Comments on Planning Application 2021/62/91239 - comments by 2nd June

The application states both existing large 5 bedroom properties and one detached double garage to be demolished and replaced by two new large 5 bedroom properties and a double garage with a large home office above.

**Fig 3. Huddersfield TPO and Trees within Conservation areas (showing woodland priority habitat network (England) High Spatial Priority)**

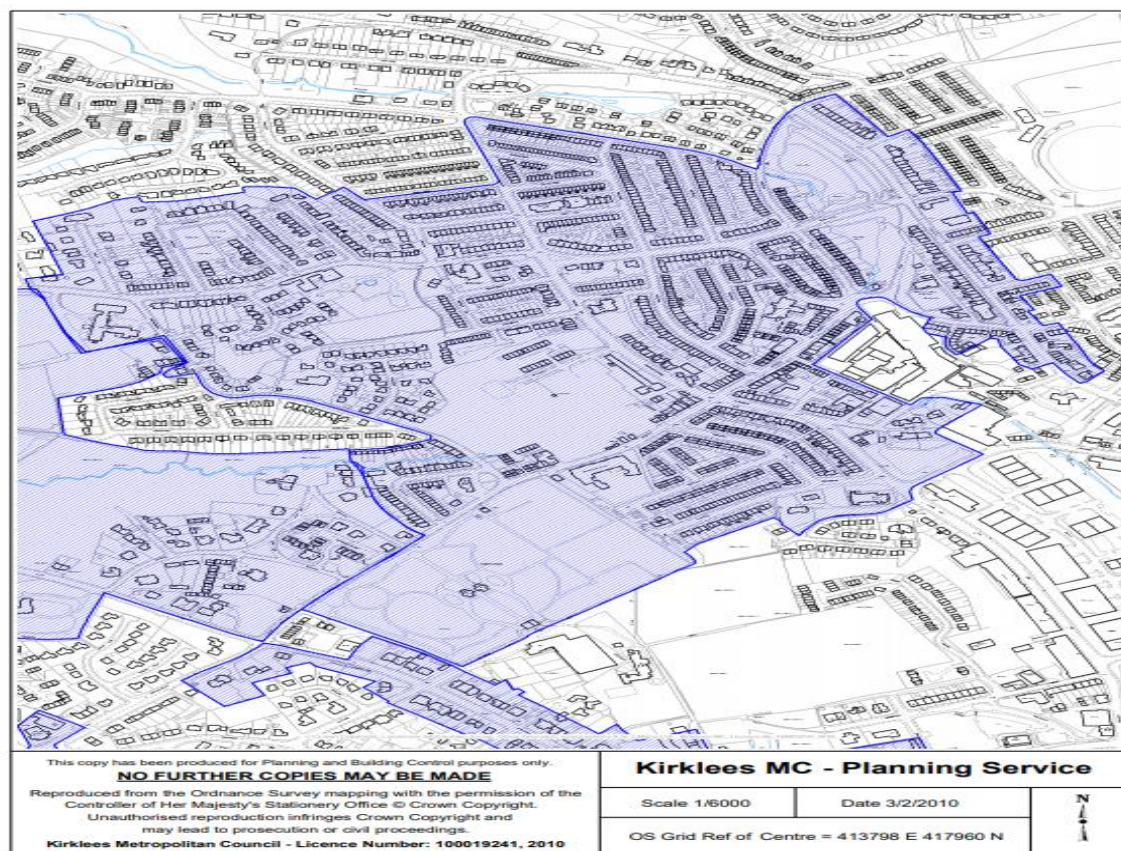
This woodland is apparently High Spacial Priority Woodland with tree preservation orders. The proposed house would lead to felling of trees covered by TPOs plus smaller trees and shrubbery

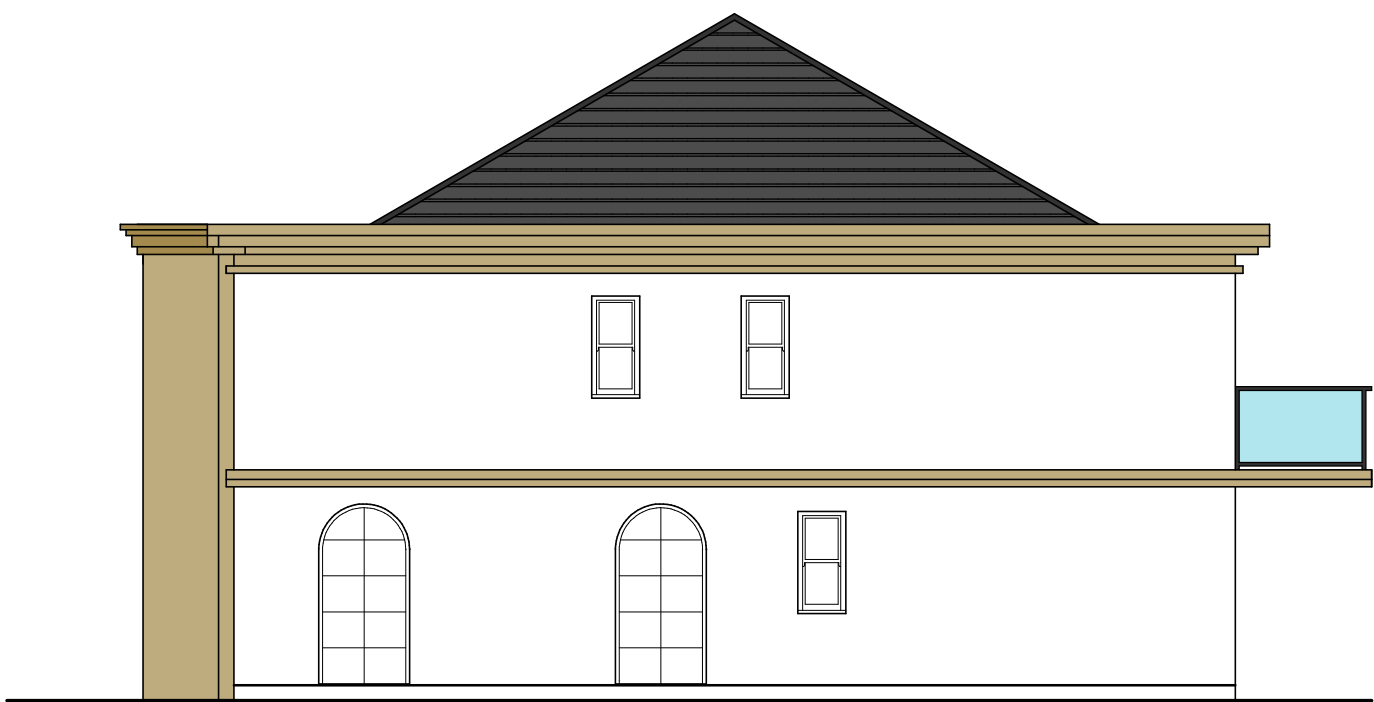
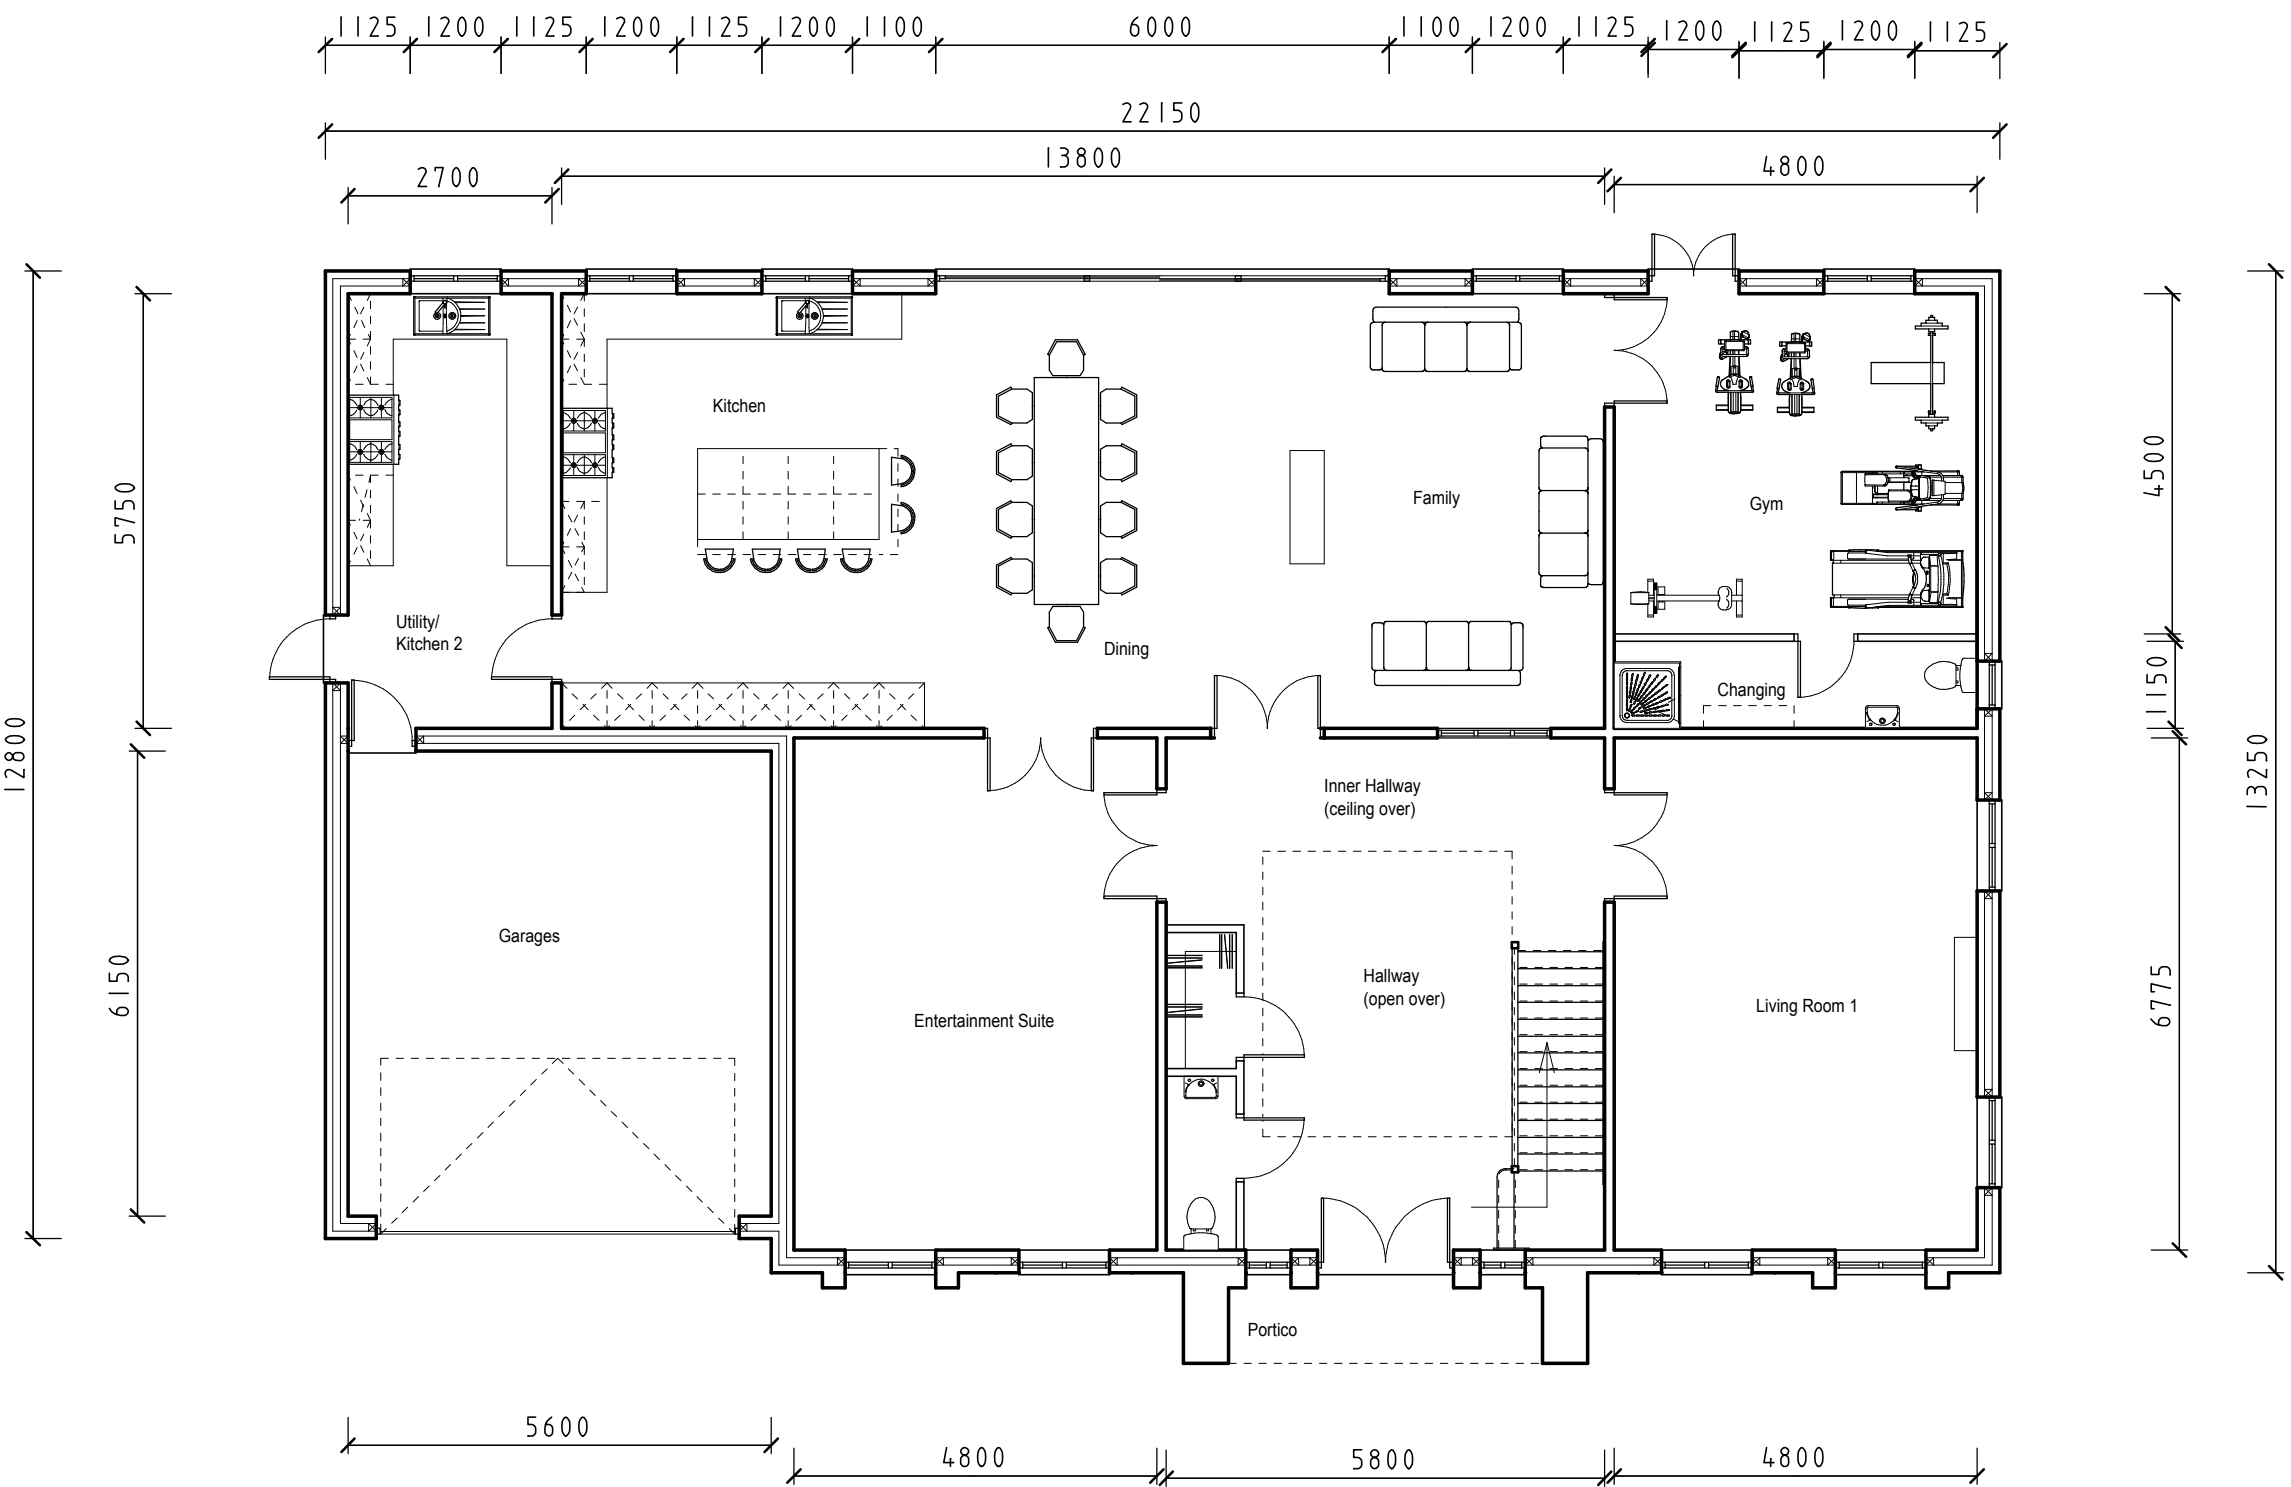
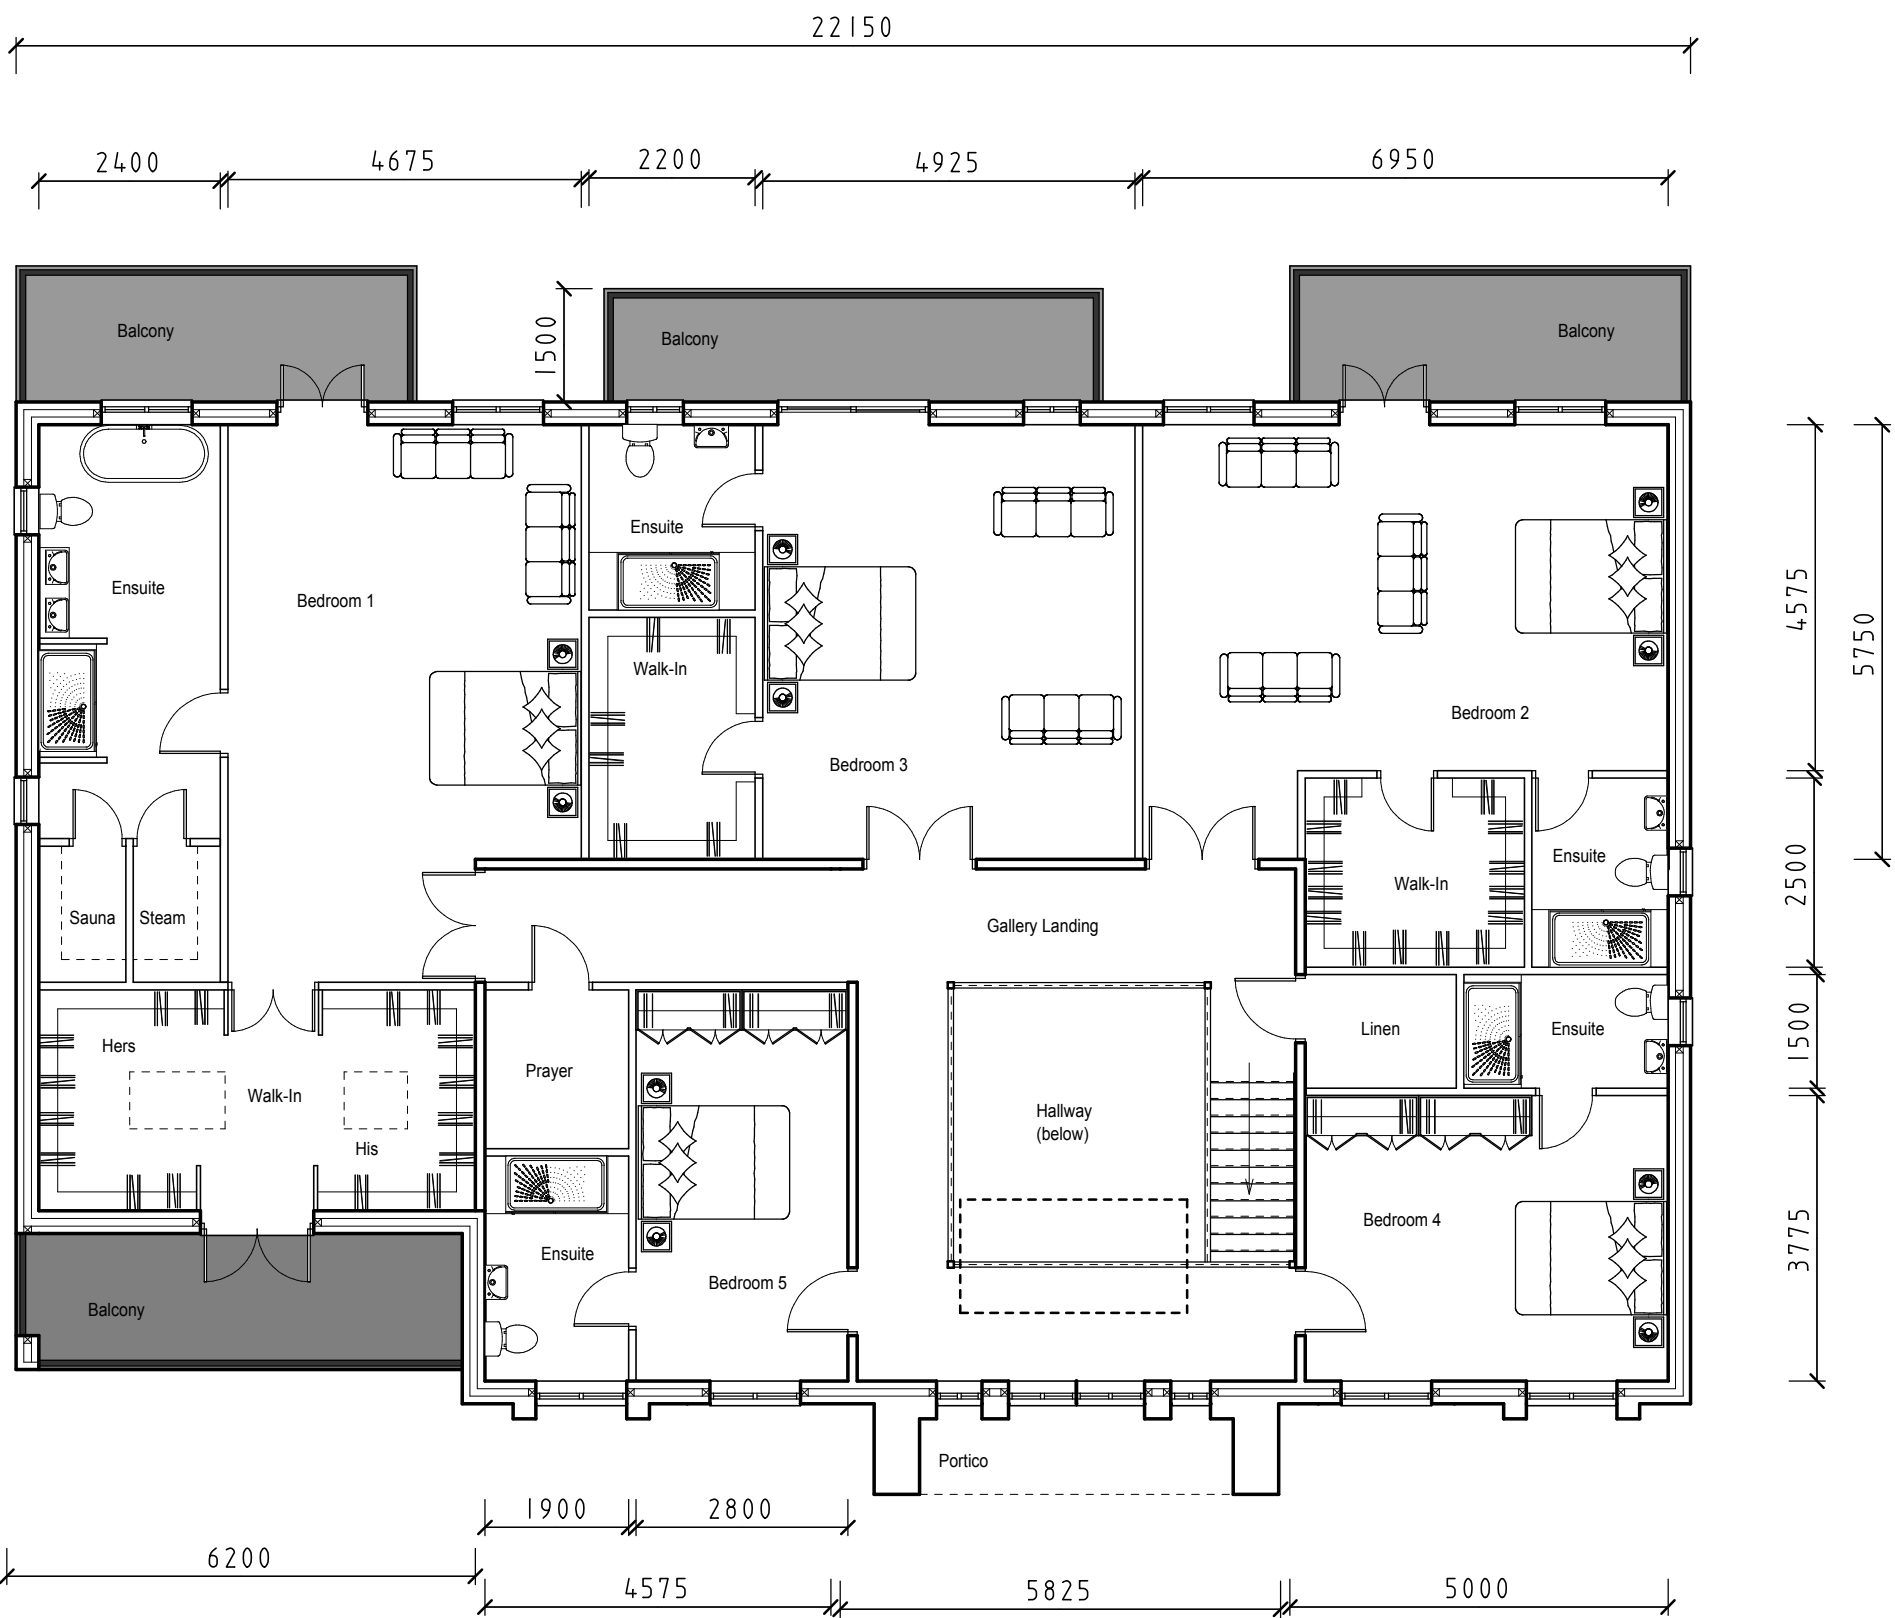
However we do object to the plan for 410, given its proposed position. The existing large 5 bedroom dormer bungalow already faces across Grimscar valley. The proposed plan shows the replacement larger 5 bedroom house encroaching into the protected woodland to its east.

Not only would building into the woodland and very close to the boundary mean felling TPO trees plus other trees and shrubs but because 410 plot slopes down to the boundary a large long retaining wall and pile driving within the woodland would be needed to support the proposed house. How on earth can these major works be considered appropriate in protected woodland and even actually take place in such a restricted space. The woodland should remain exactly as it is and not be replaced with a visually assertive retaining wall and large house so near its eastern boundary. Part of this retaining wall could extend adjacent to our property. If there are any trees remaining any damage to their roots and growth from the pile driving may not become apparent for 2-3years. These are very large mature trees whose roots will radiate in all directions- including eastwards to our home and
